Highways, Transportation and Road Safety
2 Blaenant – Emmer Green
Reading – RG4 8PF

Our Ref: RSA-16-069-L001

Friday 4th July 2017

Re: Land off A259 New Road, Rustlington

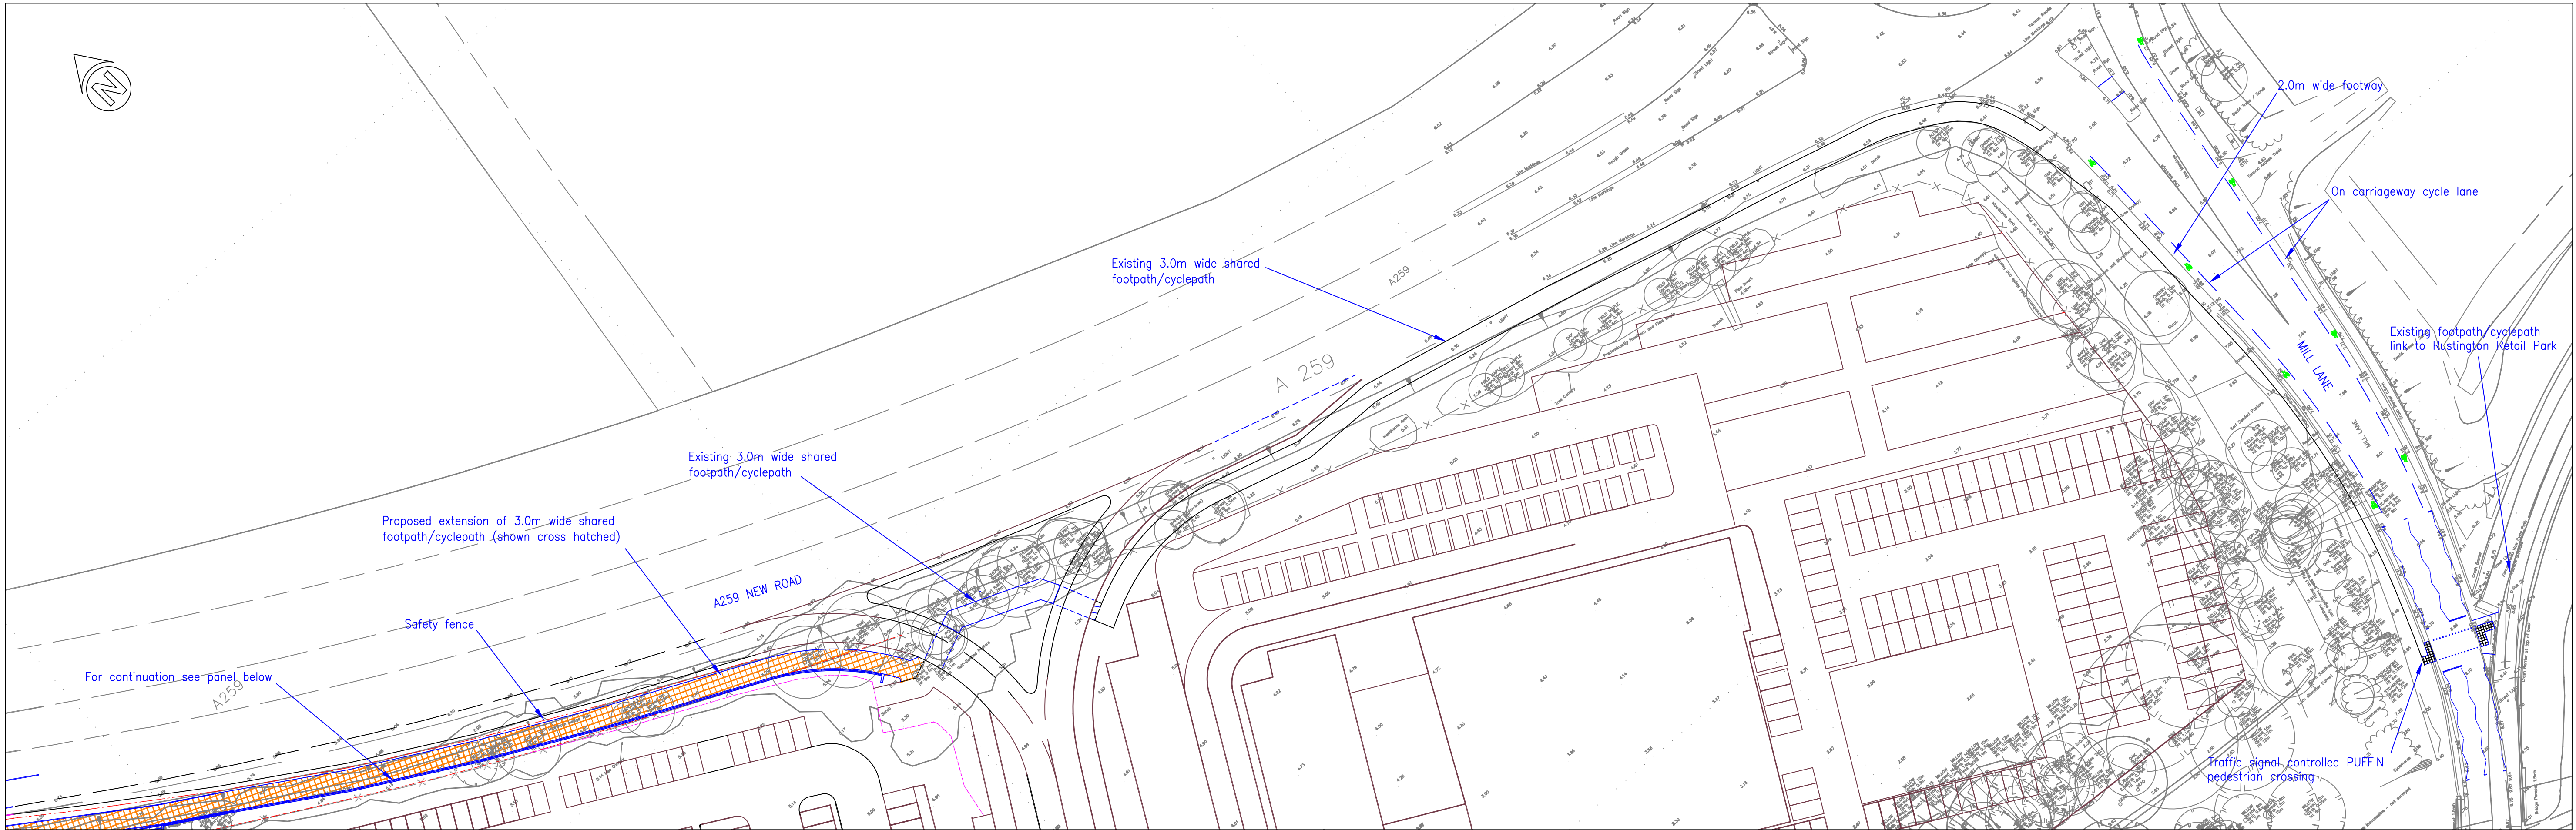
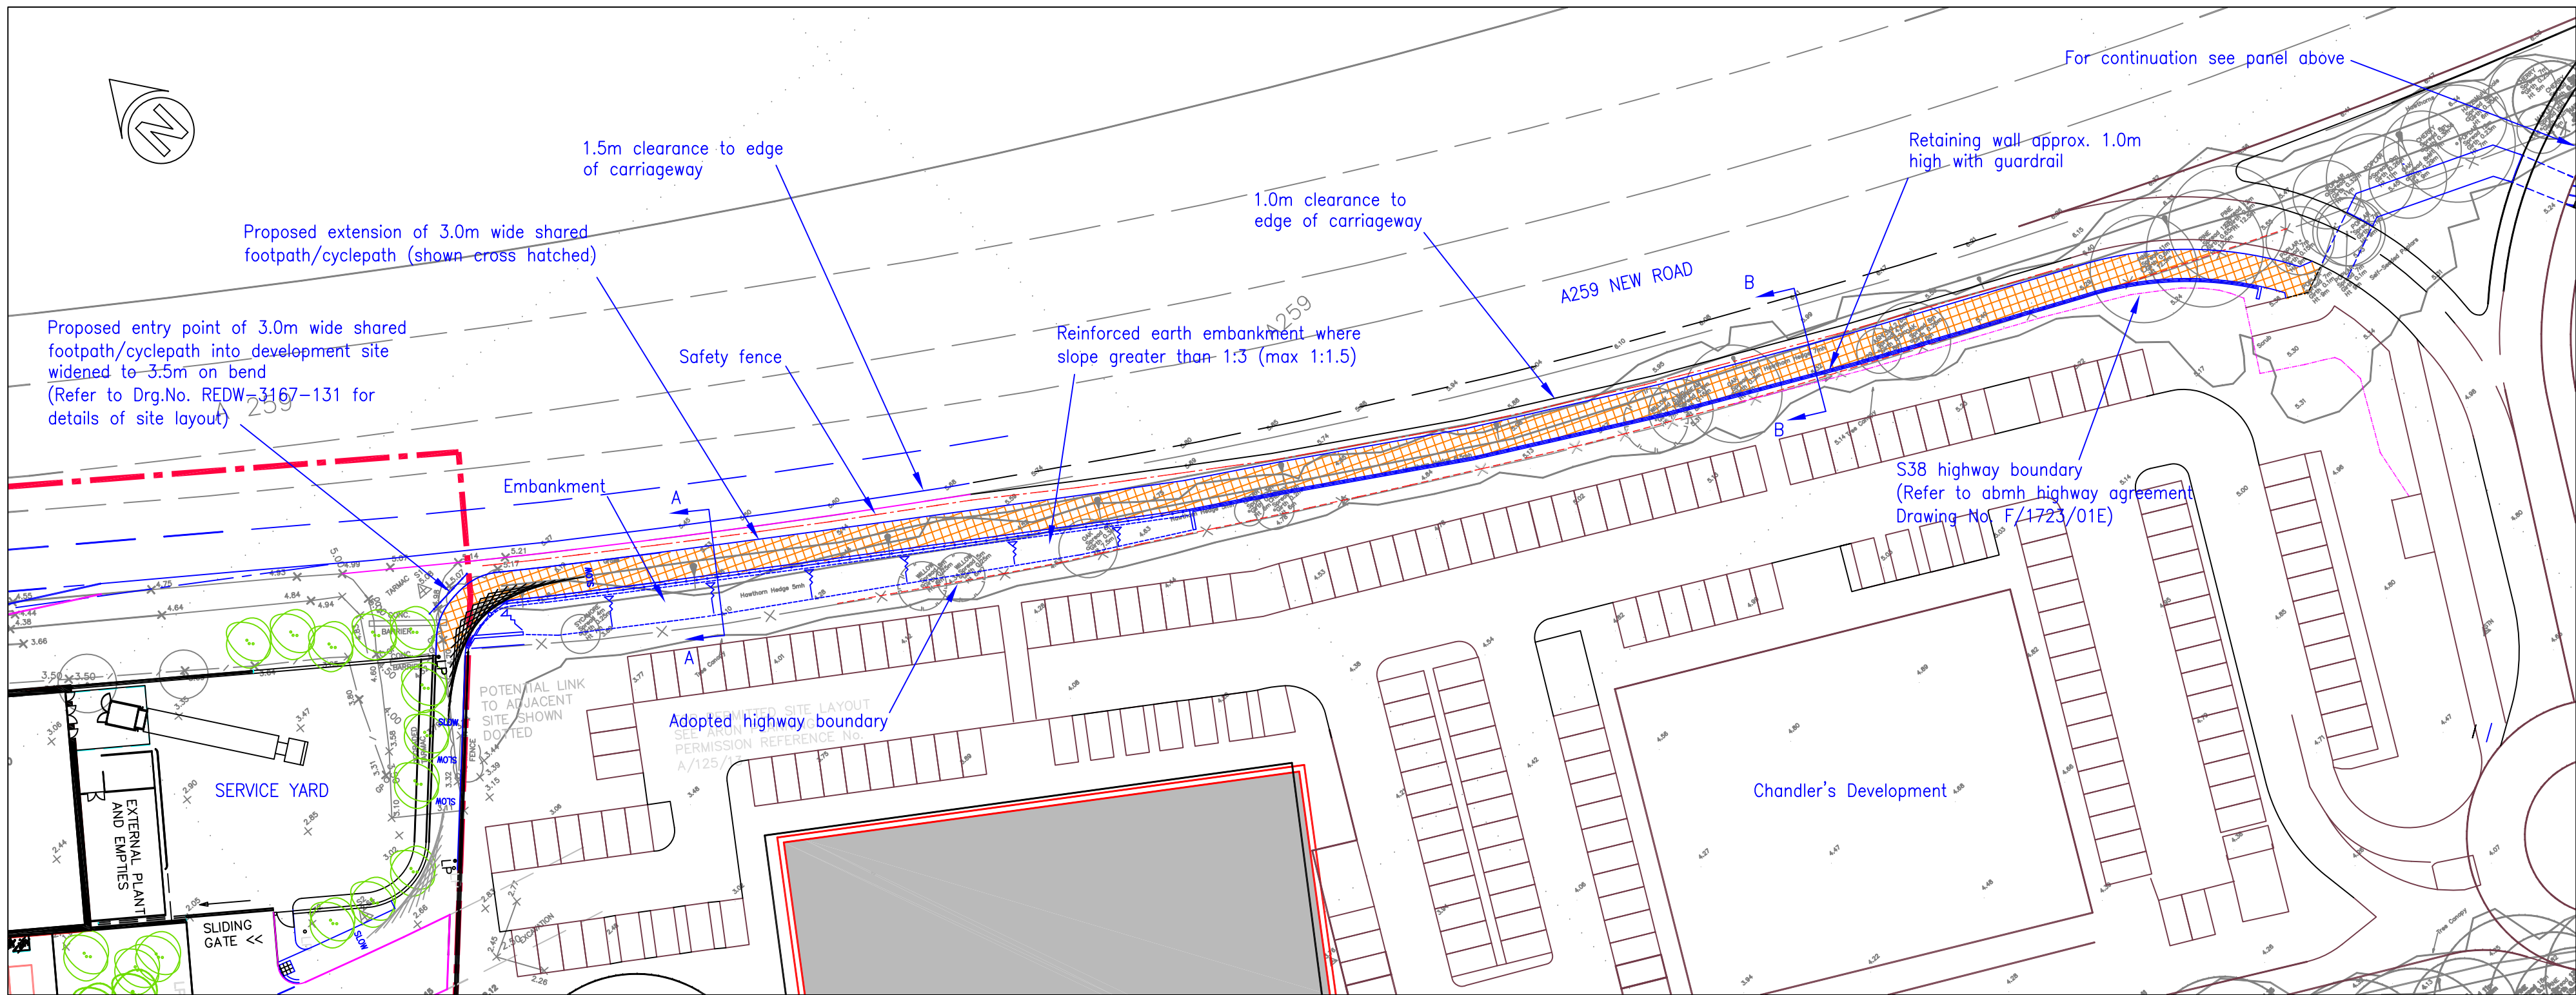
The item was raised to highlight a problem arising when a vehicle egressing the adjacent development along the acceleration lane attempts to merge onto the A259, whilst a vehicle attempts to manoeuvre into the offside lane in order to utilise the deceleration lane of the current proposals. It is likely that the driver of both these vehicles will focus on vehicles within the offside lane and could therefore miss a vehicle moving into their current lane. Moreover, vehicles egressing the adjacent development could assume that a vehicle indicating to turn off the A259 into the proposed development was slowing to enter the adjacent development and undertake their manoeuvre to access the A259 when it is not safe to do so.

The original scheme, illustrated on drawing ref. REDW-3167-120 included a weaving length of just 45 metres whereas the revised proposals, illustrated on revision A, include a weaving length of 90 metres.

Forward visibility from the roundabout to the east, towards the merge lane of the adjacent development is unrestricted and therefore approaching drivers wishing to access the proposed redevelopment should become aware of vehicles egressing the adjacent development, whether in the inside or offside lane, and drive appropriately. Furthermore, the provision of an appropriate ADS, that was proposed by the Design Team in response to Item A.5.2 of the associated Road Safety Audit, should also ensure that drivers wishing to gain access to the proposed development are aware of the two accesses and approach within the offside lane appropriately.
